## Ascent Church

Final Drainage Report

PPR265

All Terrain Engineering Project No: 25023

# ASCENT CHURCH PCM APPLICABILITY MAP

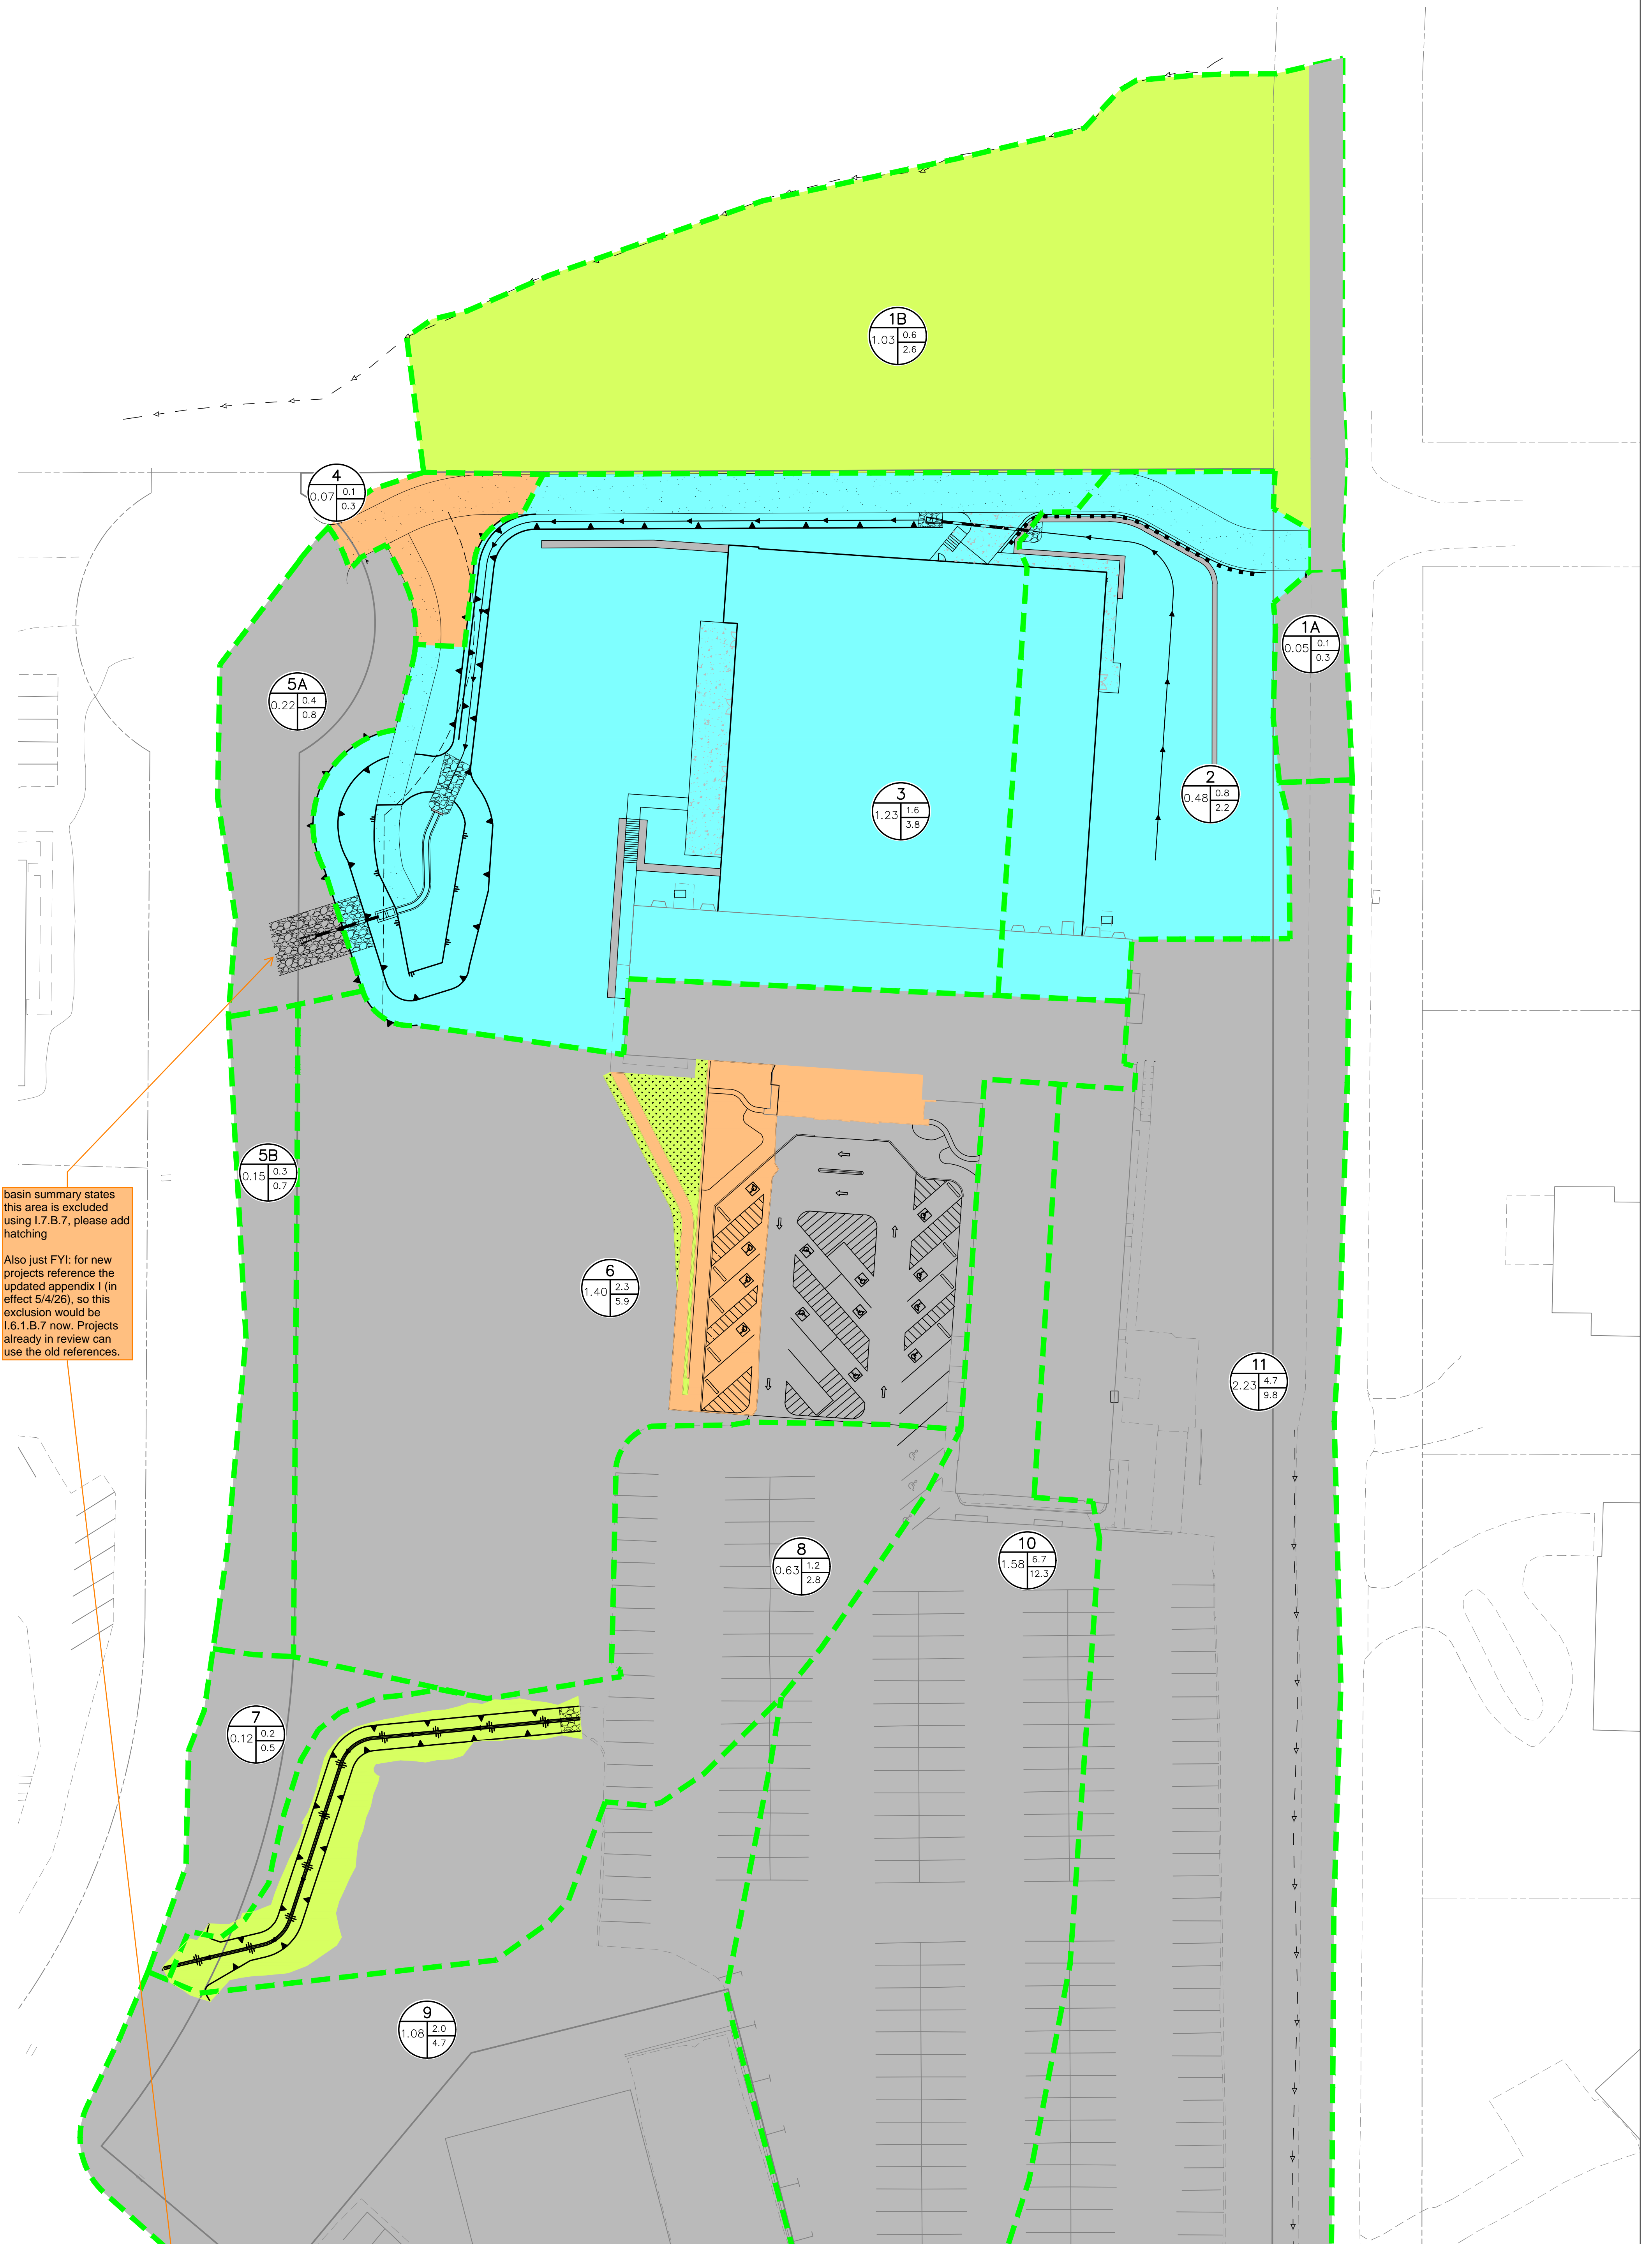
Basin 1 is 0.67 acres of on-site and off-site undeveloped area. The proposed disturbance will place excess fill from the site's building excavation. Existing drainage patterns will be maintained. Upon completion of grading of the offsite area. However, additional survey is required to accomplish this. Once survey has been completed, an updated design and analysis for this area will be presented. Basin 1 stormwater ( $Q_5 = 0.2$  cfs  $Q_{100} = 1.5$  cfs) will follow historic drainage patterns to DP1 ( $Q_5 = 0.2$  cfs  $Q_{100} = 1.5$  cfs). At DP1, an existing, unnamed drainage conveys Basin EX1 flow to Crystal Creek. Basin EX1 is excluded from water quality and detention per EPC ECM Appendix I, Section I.7.1.B.7.

All Terrain: addressed, see revised basin description. Please note, design did not change, However, we have received the corresponding topo & updated the offsite grading to tie in.
